Richard Allarton objections to the Great North Road Solar Park photovoltaic system

I would like to raise concern regarding the development of the Great North Road Solar and Biodiversity Park (GNR Solar) by Elements Green (Trent) (EG). In particular, I would like to explain in greater detail the concerns presented in my open Hearing presentation regarding the flood risk analysis of the Moorhouse area on behalf of Laxton and Moorhouse Solar Concerns.

Design Evolution - Changes from Preliminary
Environmental Information Report to
Environmental Statement
Figure 4.9b SE

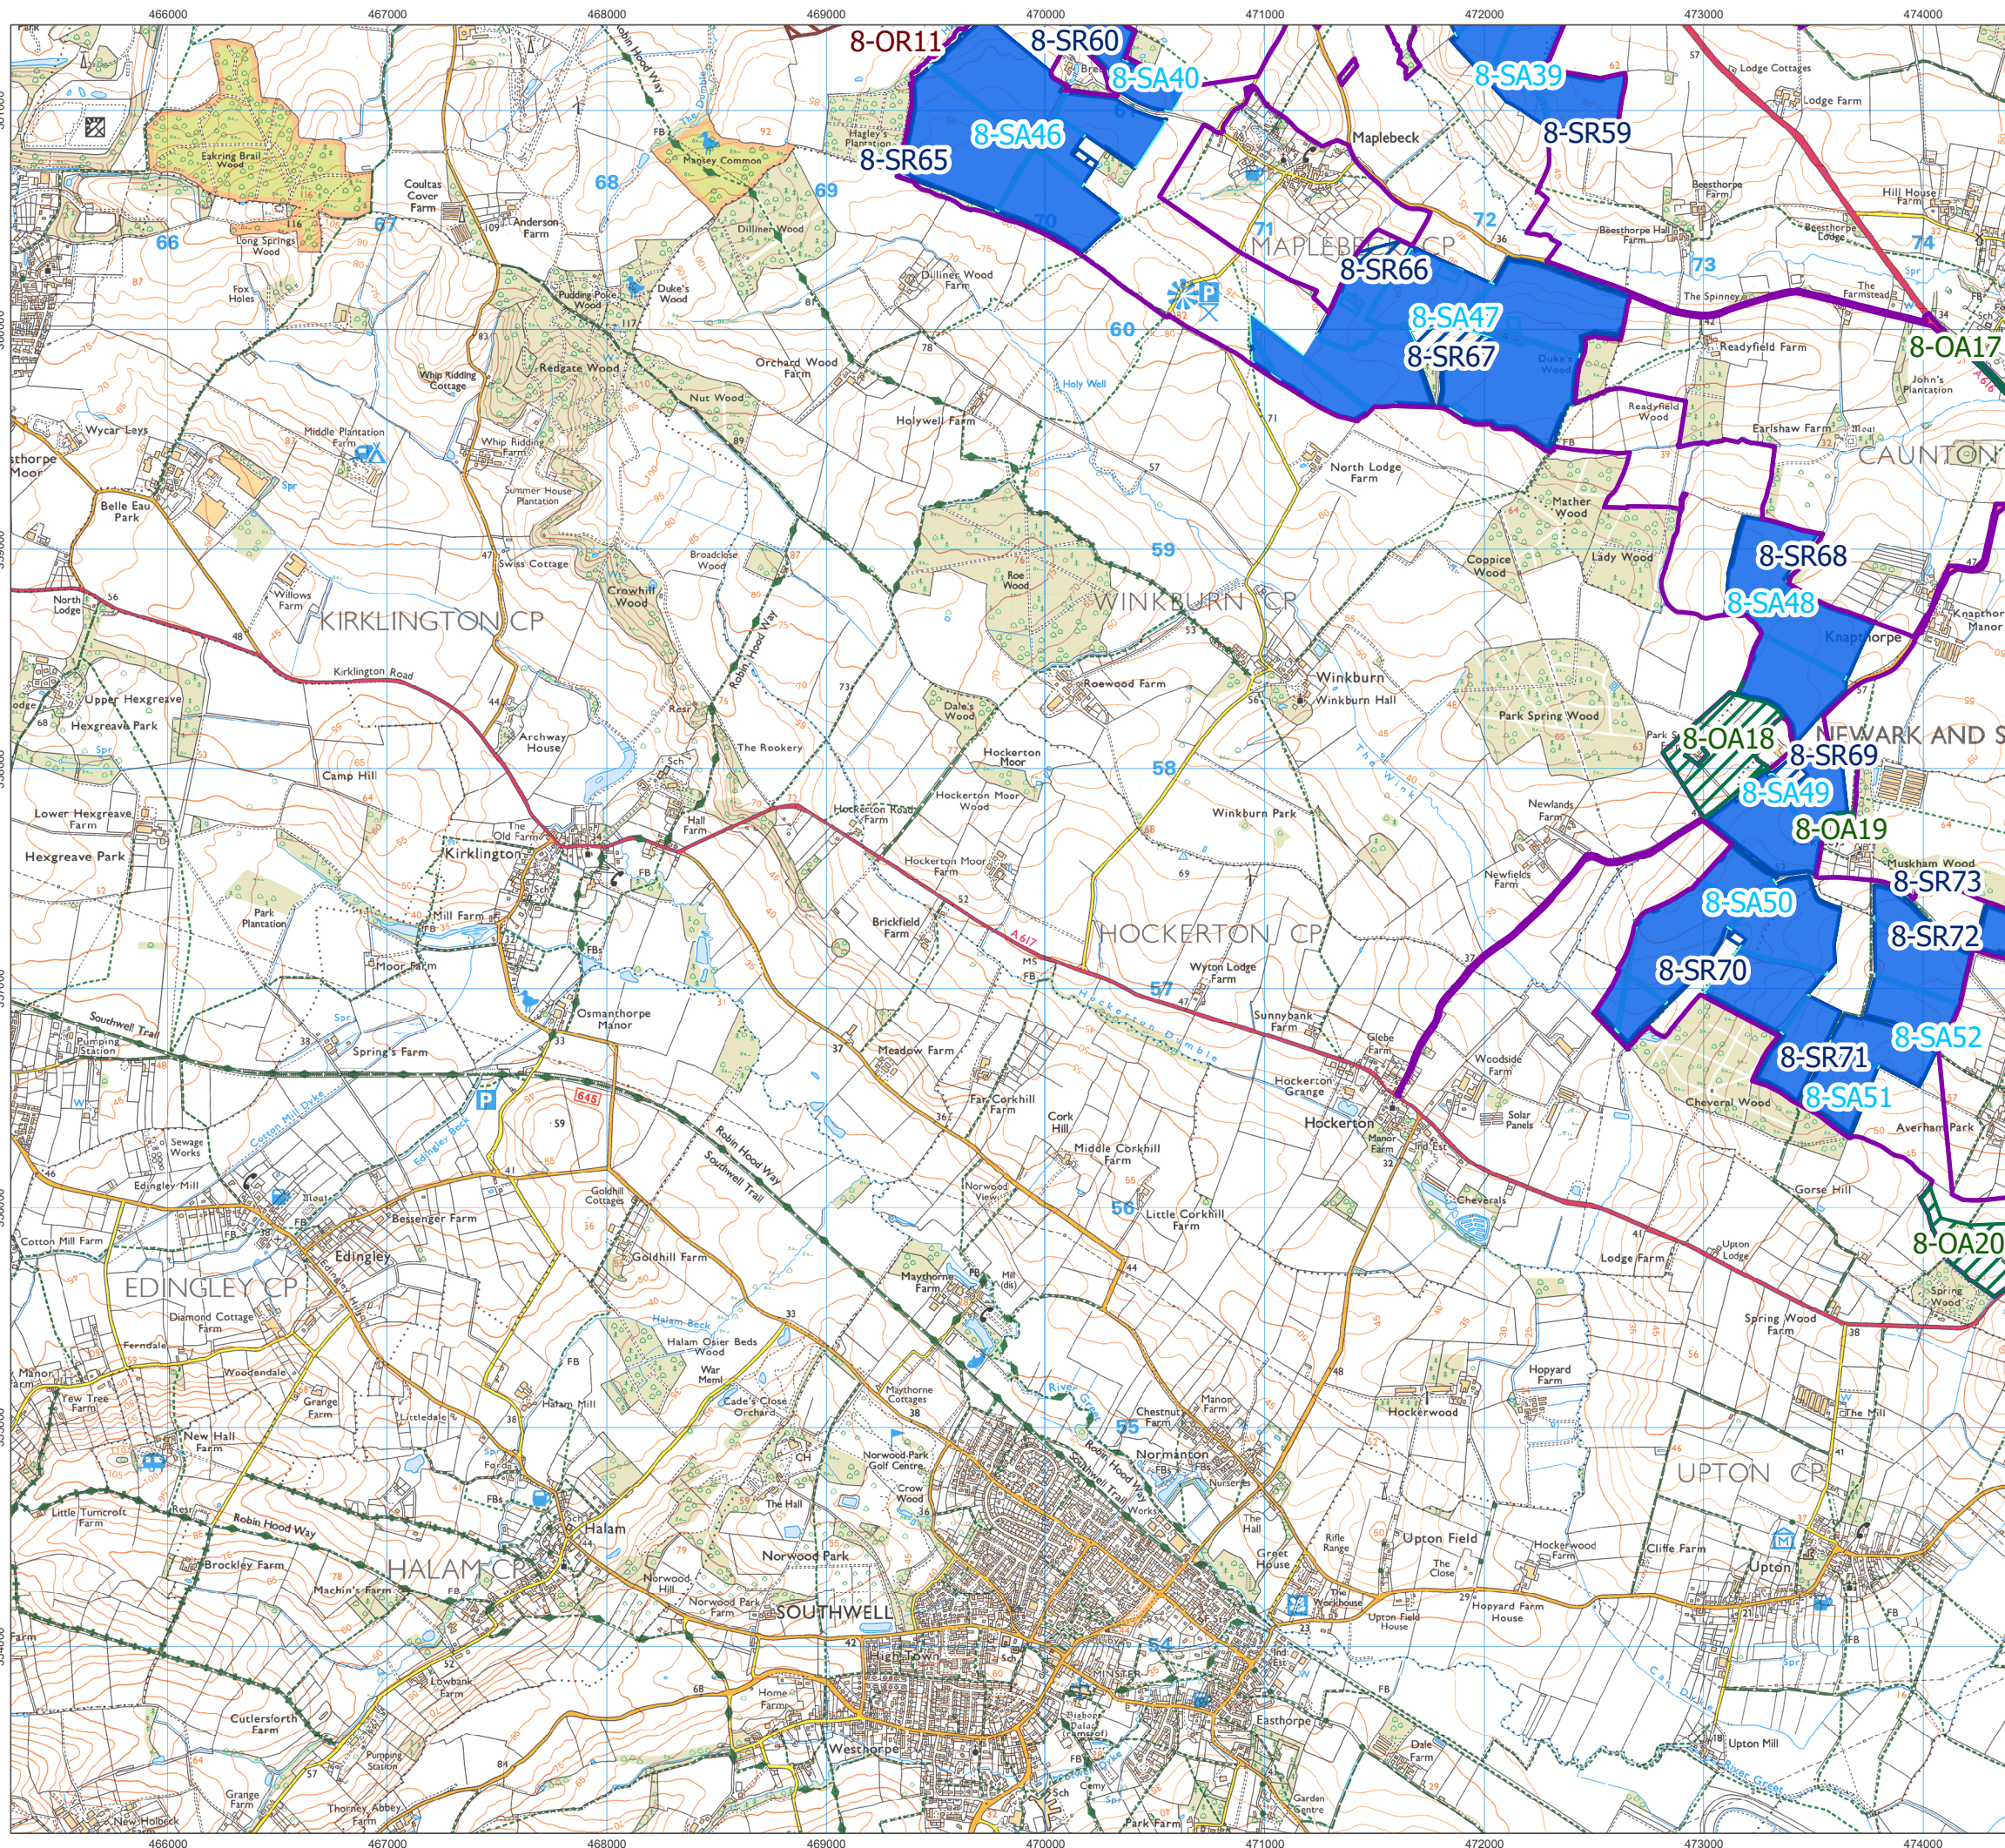
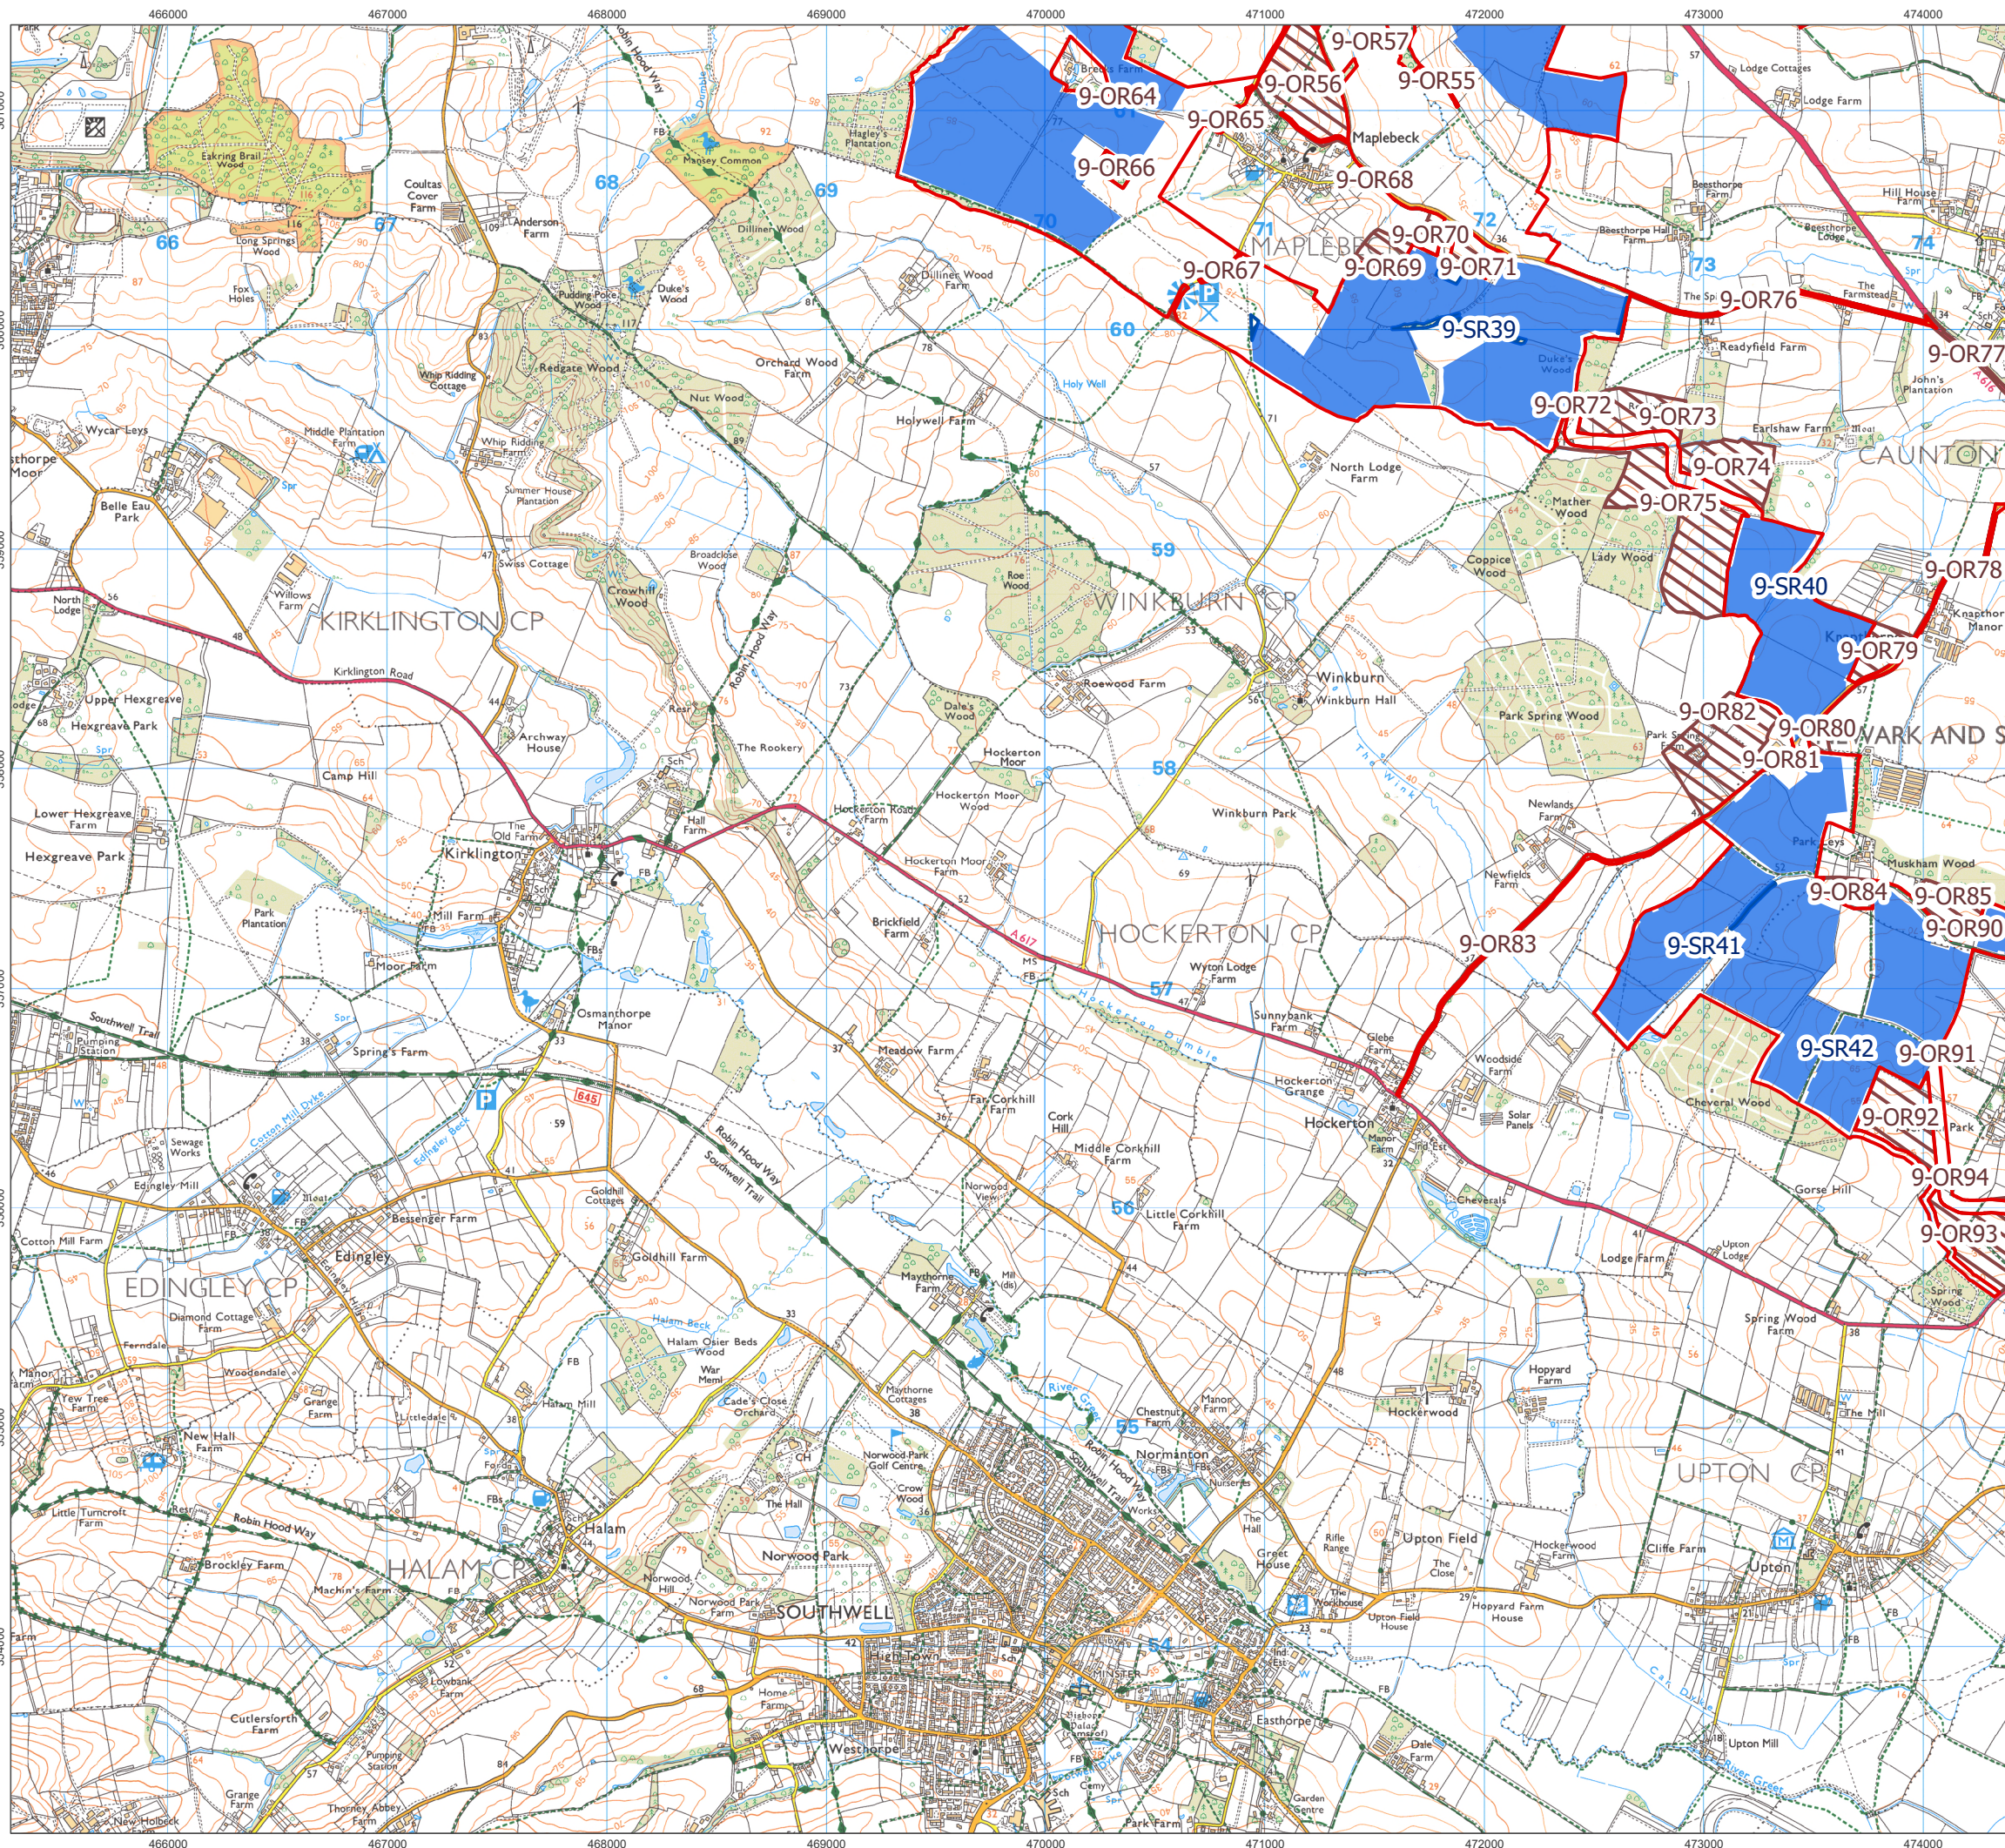
The document describes on-site research pertaining to the Moorhouse area, though yet again it is constrained solely to effects on the plant equipment. (Presumably resulting in the major project revision that saw panels originally placed on the Beck flood plain being removed, but leaving the panels that were above the perceived flood line.) These investigations did highlight when 'Moorhouse Beck overtop its banks then floodwater will spread over a wide flat area to shallow depths'. A concern raised with regard to the planned riparian planting in this area which would inhibit the overflow and flood back into the village.

Conflicting evidence gives, at the very least, rise for concern that placing solar panels along the Moorhouse Beck could exacerbate flooding in the Moorhouse area. Elements Green implicitly acknowledge this by the removal of panels on the Beck flood plain whilst leaving them in place above the flood line. They explicitly acknowledge the flooding risk in their assessment of the area but do nothing to alleviate that which does not directly affect their equipment. The limitations of the analysis have resulted in proposals for riparian planting on the flood plain, which by their own analysis will exacerbate upstream flooding if the Beck overflows in this area.
